BCA Design Assessment Report

SCEGGS Darlinghurst – Masterplan 2040
215 Forbes Street,
Darlinghurst

Project: SCEGGS Darlington – Masterplan 2040
 Document Type: BCA Design Assessment Report
 Report Number: P218_153-2 (BCA) LS

PROPOSED MASTERPLAN | WILKINSON BASEMENT

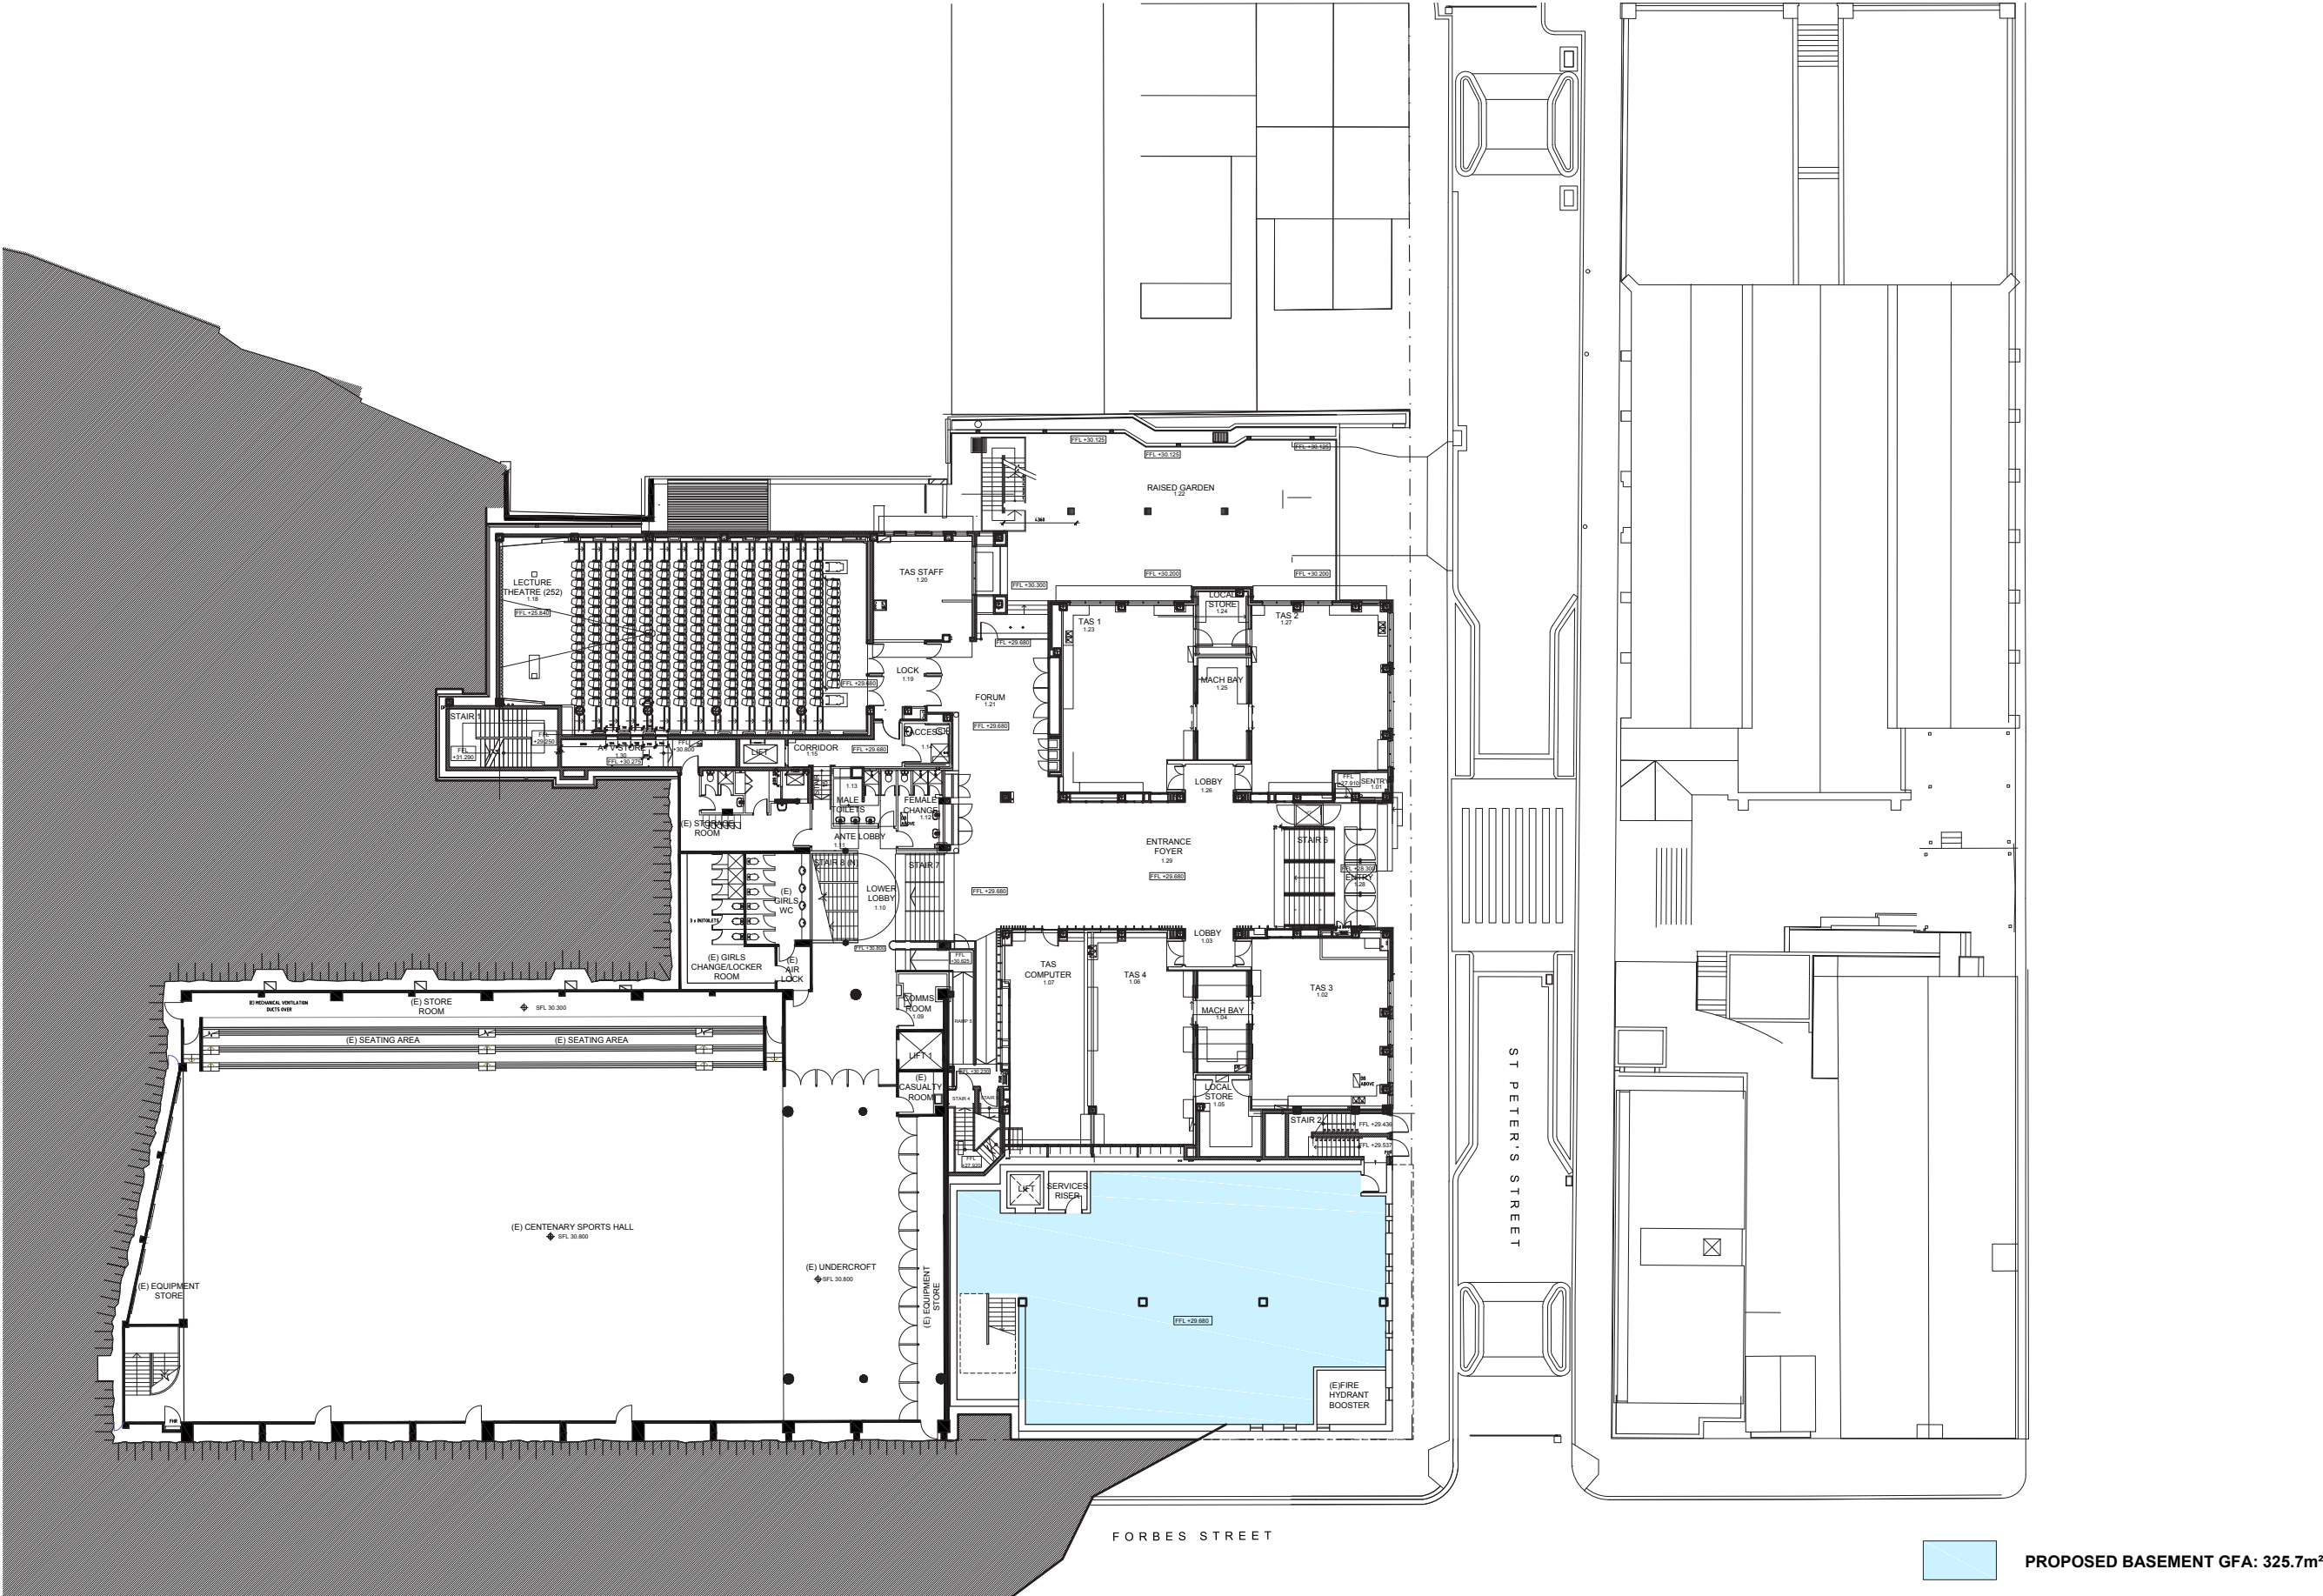
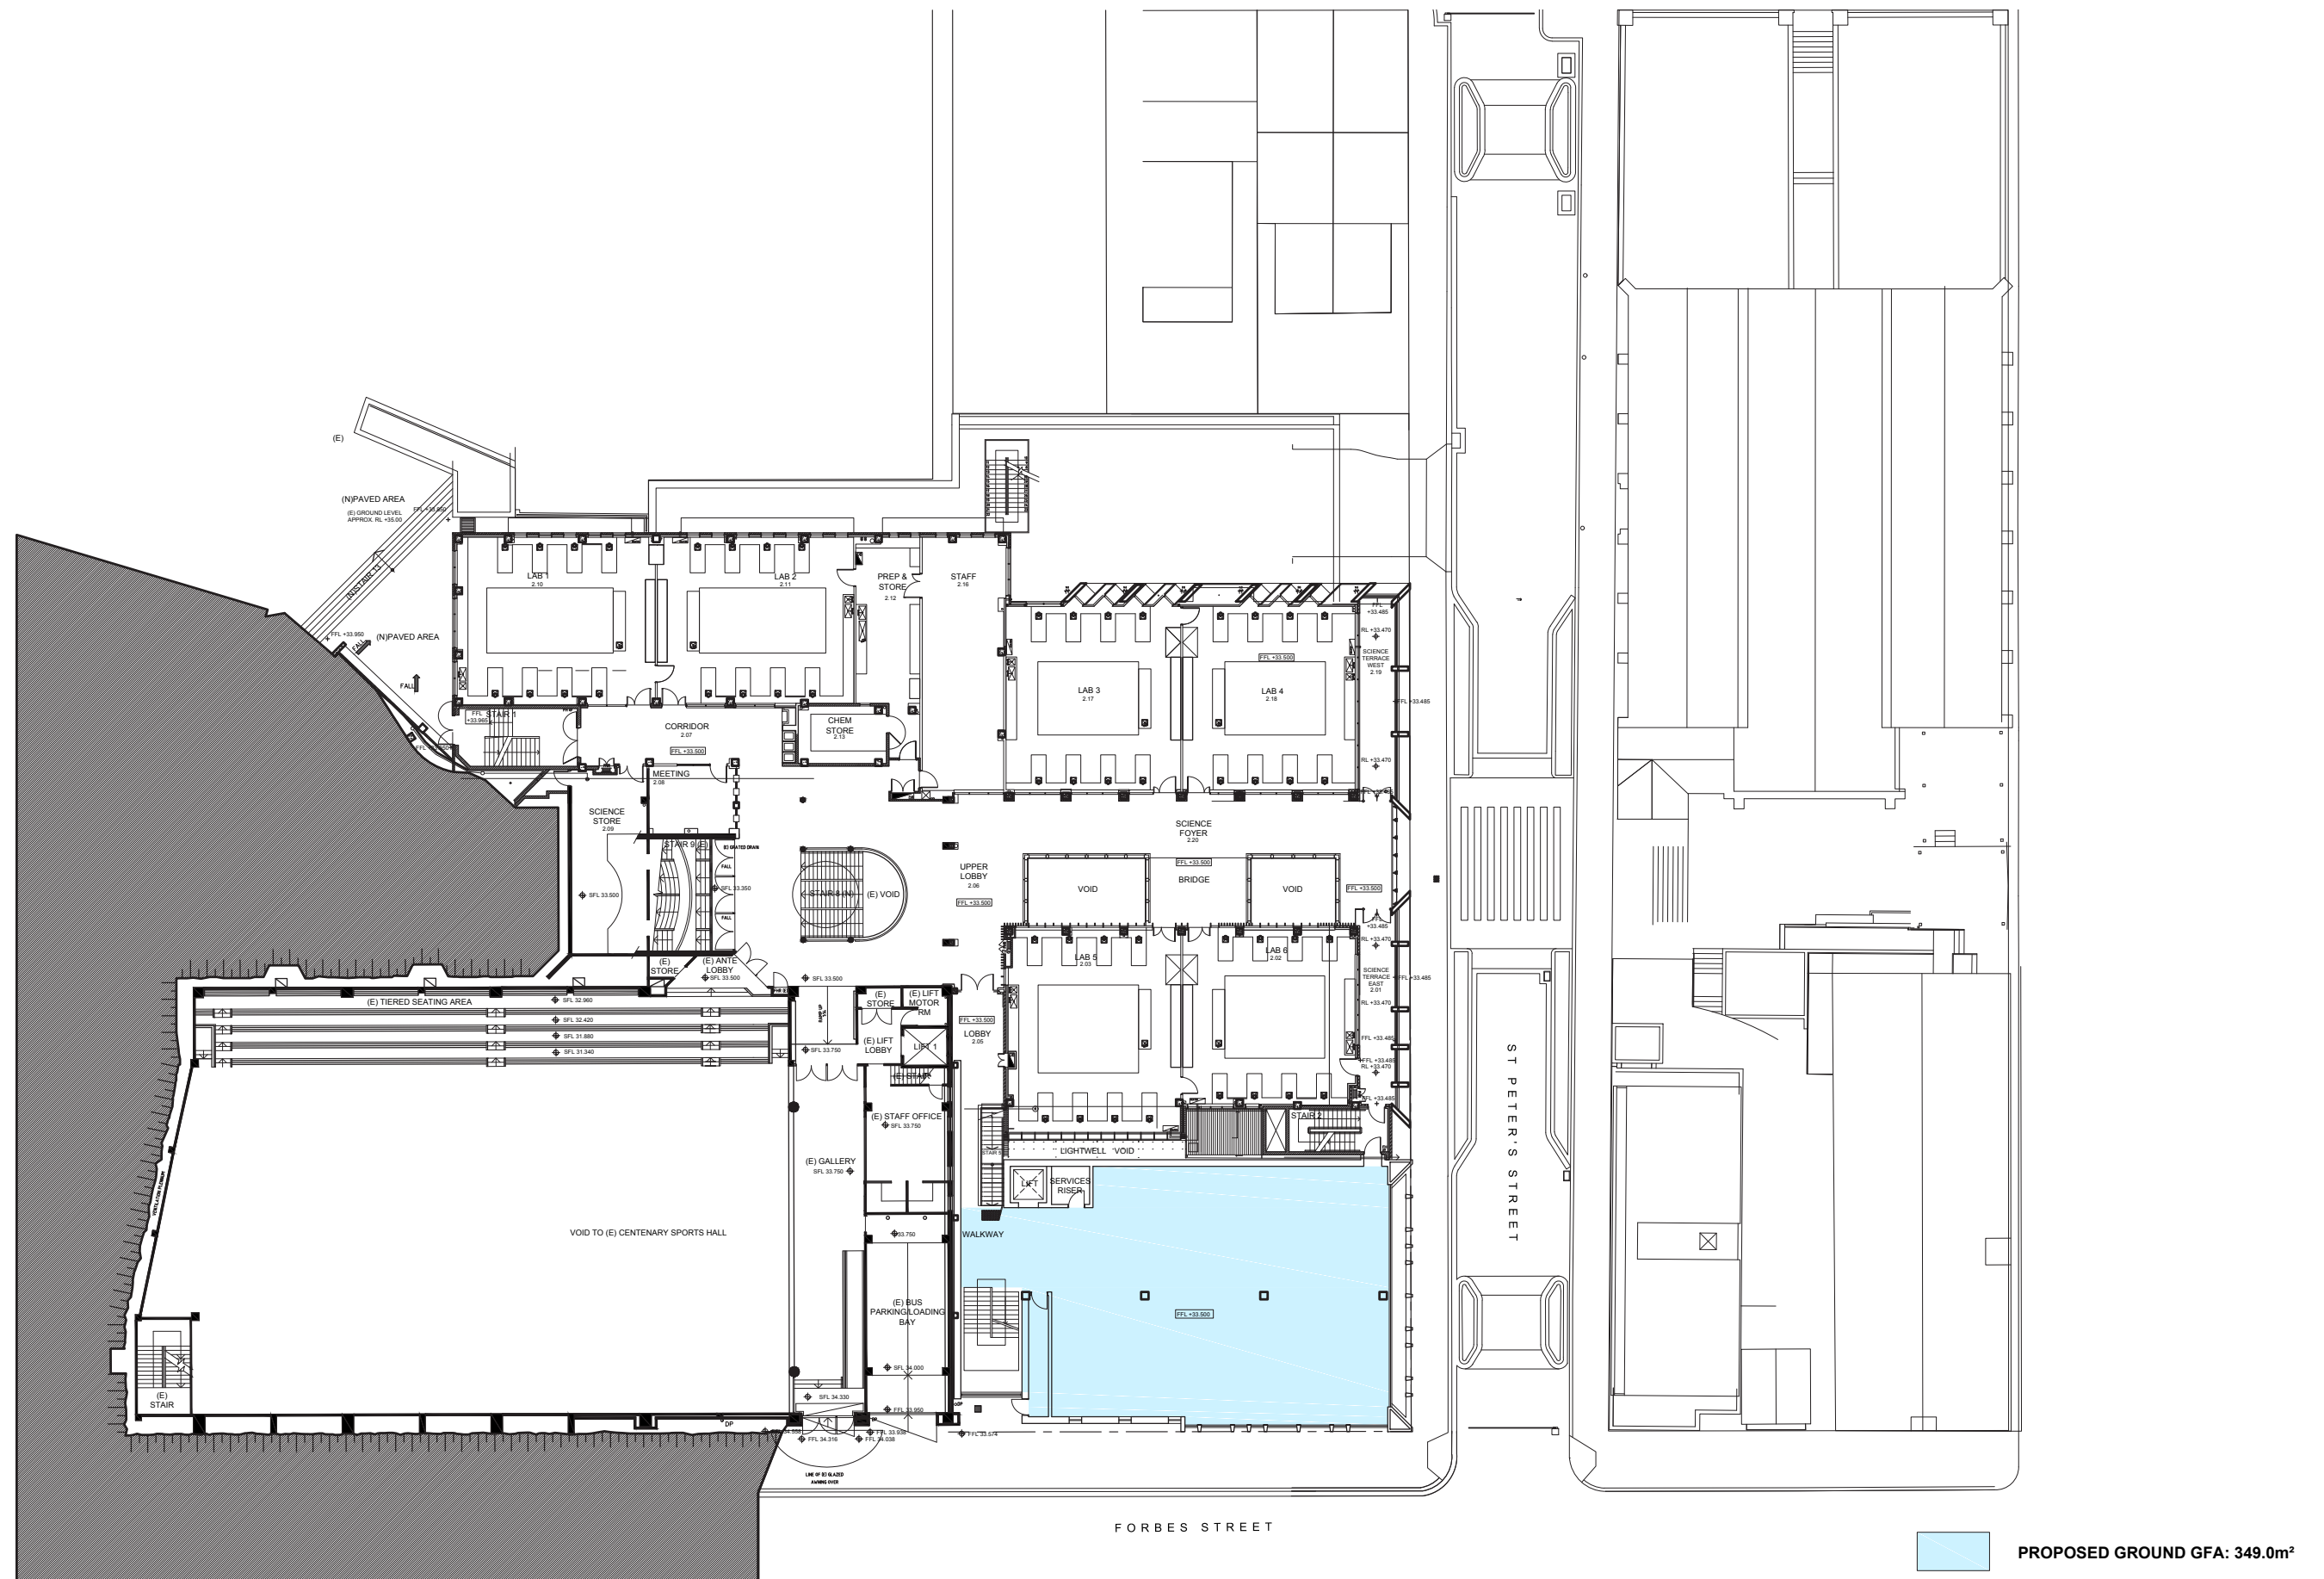
Cl. C2.2	To ensure the subject building is within the maximum floor area and volume limitations prescribed within C2.2, the building is to be separated from the adjoining building known as a the Centenary Sports Hall.
-------------	--

Compartmentation is to occur at every level, refer to Figure 1 below.

C2.7	<p>As stated in C2.2 above a fire wall needs to be introduced at all levels the buildings share a common wall or the like.</p> <p>Be advised that the DTS requirements of the BCA require the subject wall shown in Figure 1 to be constructed as follows –</p> <ul style="list-style-type: none"> (i) The passive / solid walls located between the two compartments is to achieve an FRL of not less than 120/120/120 and extend uninterrupted from the slab to slab; (ii) The doorway / opening which permits persons to pass through is to via a self-closing fire-rated doorsets that is tested to achieve an FRL of --/120/30
C2.10	<p>The lift shafts are required to achieve an FRL of 120/120/120 or --/120/120 (if non-loadbearing).</p>
C2.11	<p>The stairway and passenger lift proposed within the lobby connect five storeys (basement to level 3) and therefore are required to be fire-isolated and located in separate shafts.</p> <p>The proposal currently shows the subject stairway and lift in the same shaft and whilst the lift is located within a shaft which can be fire-rated appropriately the stairway is not enclosed / fire-isolated.</p> <p>The stairway design is discussed further in clause D1.3, however the current design may be capable subject to a performance based approach be adopted.</p>

C3.5	<p>As discussed in C2.2 and C2.7 above a fire wall needs to be introduced at the lower ground floor level to divide the building into two separate compartments and any opening located within this wall is be a self-closing fire door which achieves an FRL of --/120/30.</p>
C3.10	<ul style="list-style-type: none"> (i) The doorways providing access to the lift shaft shall be protected by --/60/-- fire doors complying with AS1735.11-1986 and remain closed except when discharging or receiving passengers or goods; and (ii) Any lift call button, indicator panel or other panel located within the wall of the fire-isolated lift shaft must be backed by construction having an FRL of --/60/60 if it exceeds 35,000mm² in area.
Cl. C3.12	<p>Where a service passes through a floor required to achieve an FRL, that service is required to be protected by either a shaft which has been construction in accordance with BCA Spec C1.1 (listed above) or in accordance with C3.15 (see below).</p>
